Drafted 10 April 2012

**Planning Application, Ribble Valley District
D3-12-0181 3 Woodlands Drive, Whalley**

Proposed Site & Ground Floor Plan

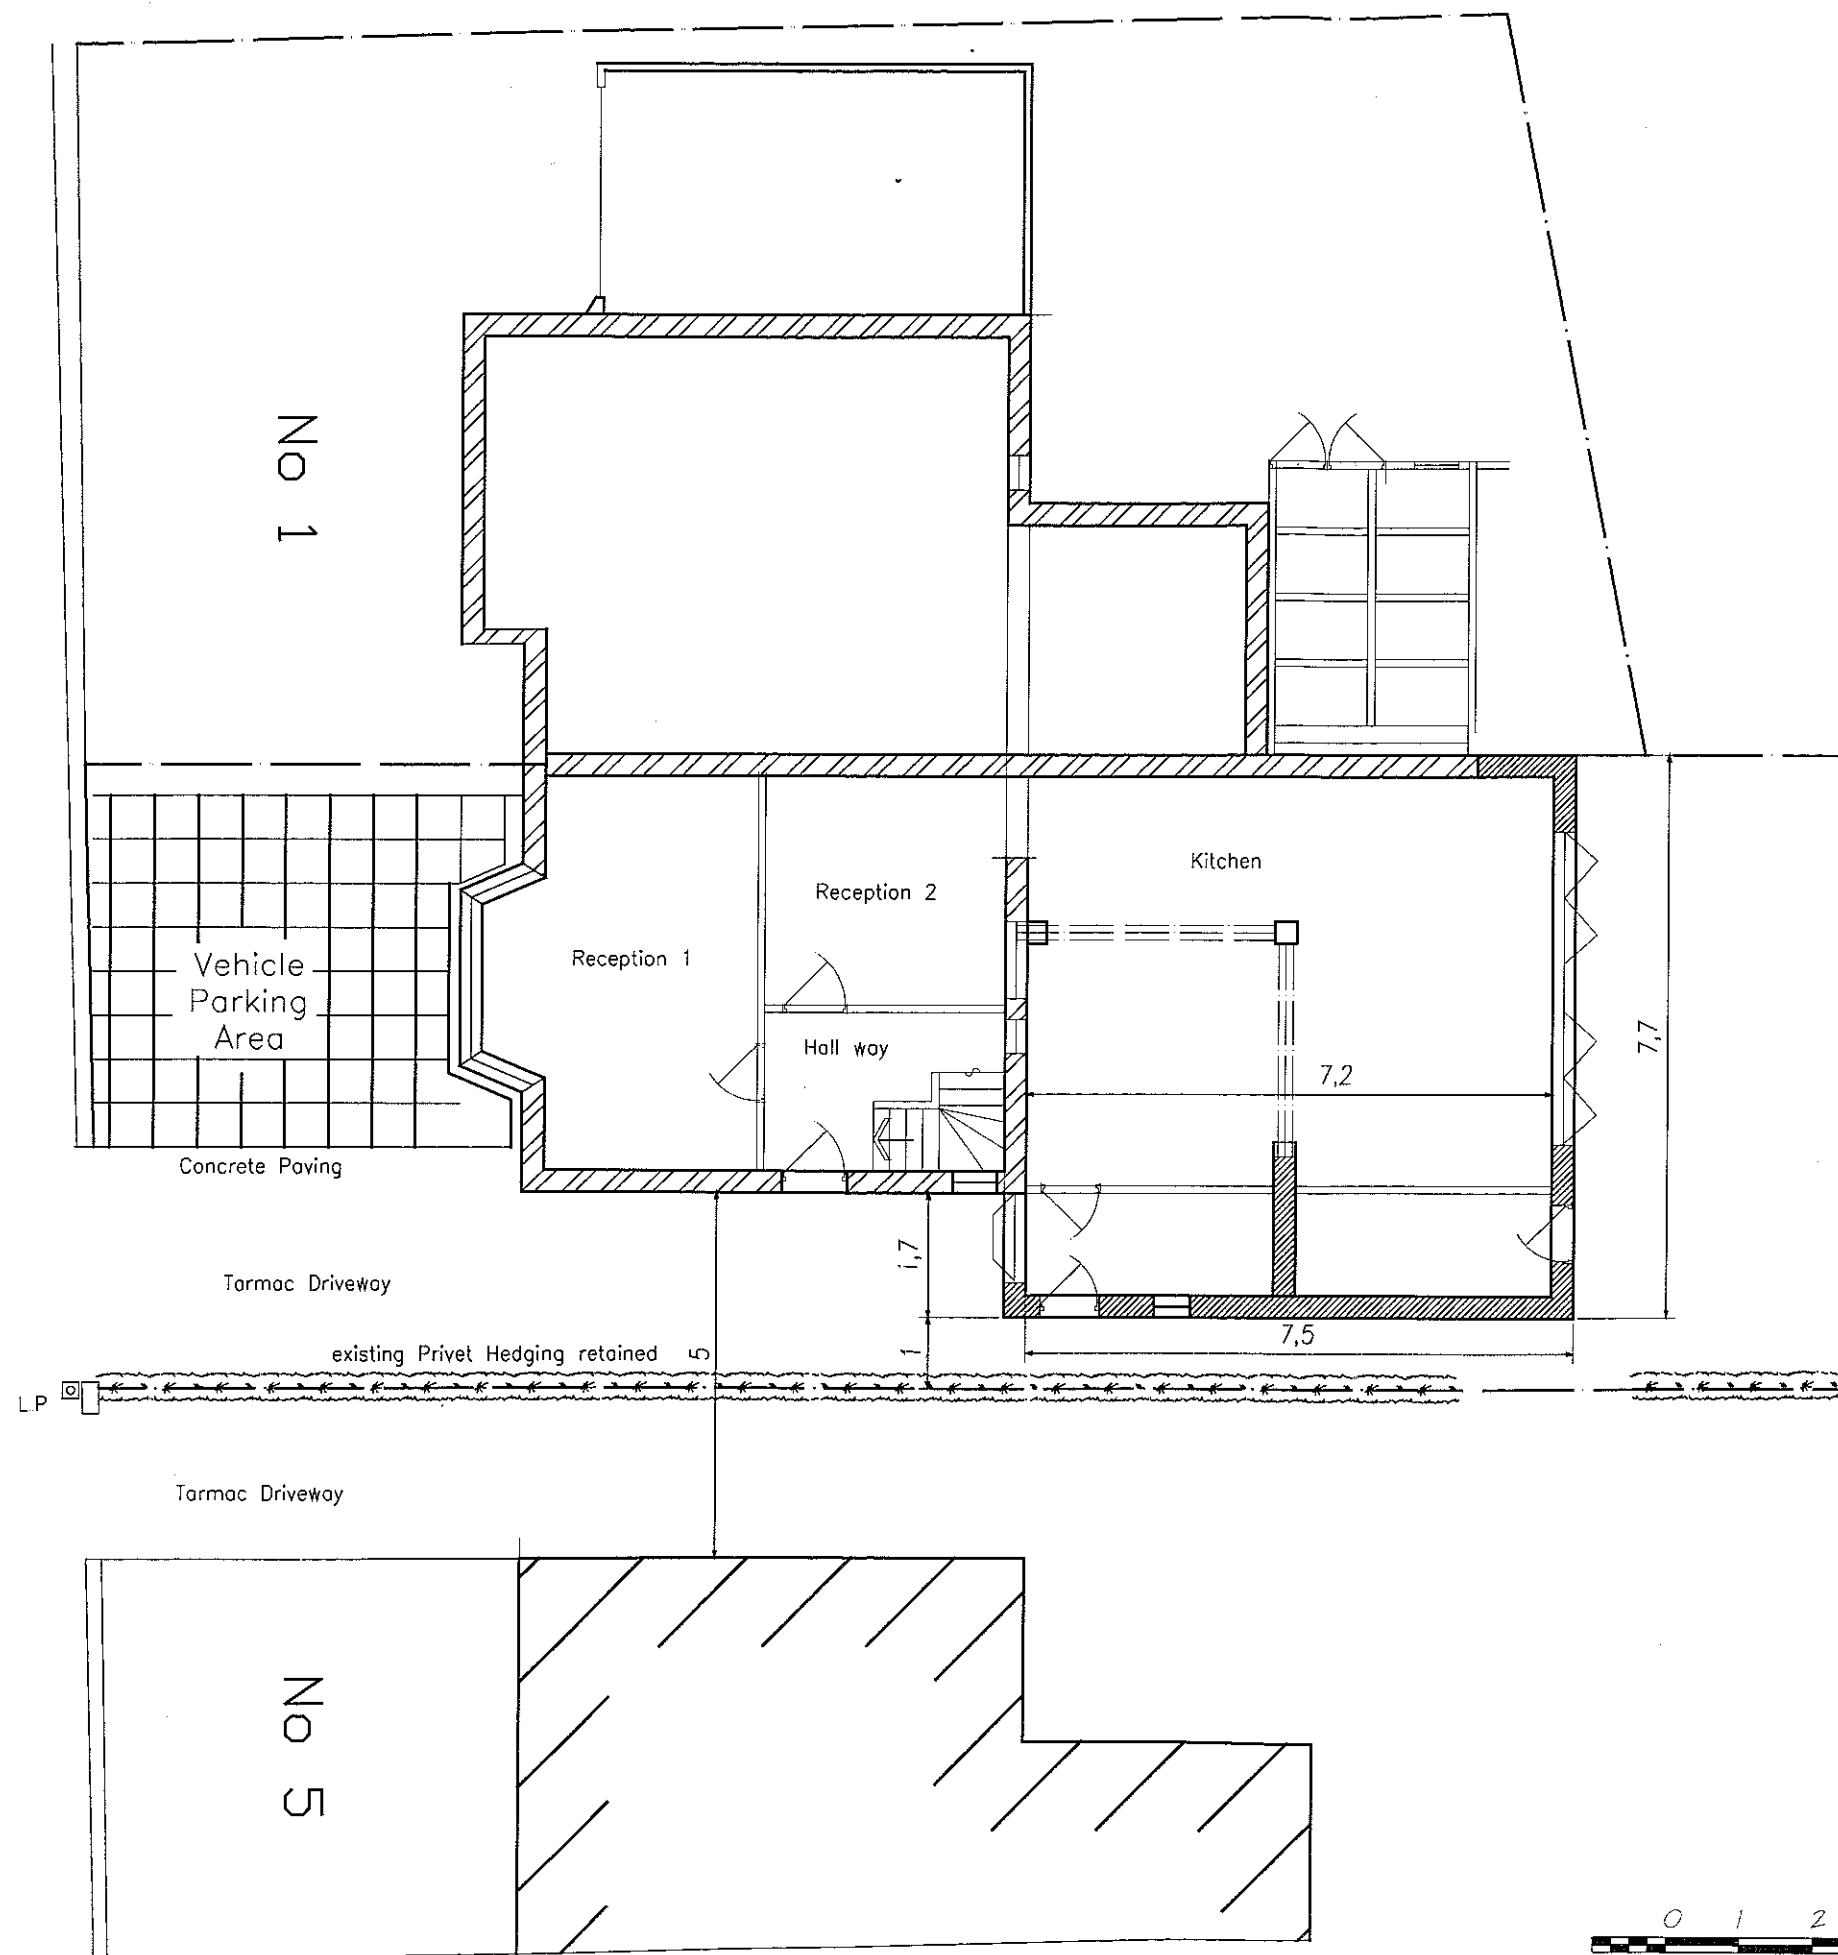
The applicant has not shown that the development can accommodate off street parking for three vehicles within the remaining driveway. This is considered necessary for the activity likely to be generated by a four bedroom residential property.

There is already a high demand for the available on street parking within this residential area. The introduction of additional vehicles relying on the existing on street provisions would increase turning movements and congestion in this confined area to the detriment of residents and other road users.

Furthermore, given the close proximity of the site to the adjacent bus station, I would be concerned should there be any residential parking displaced from this address, to the potential detriment of the safe and efficient movement of public transport in this vicinity.
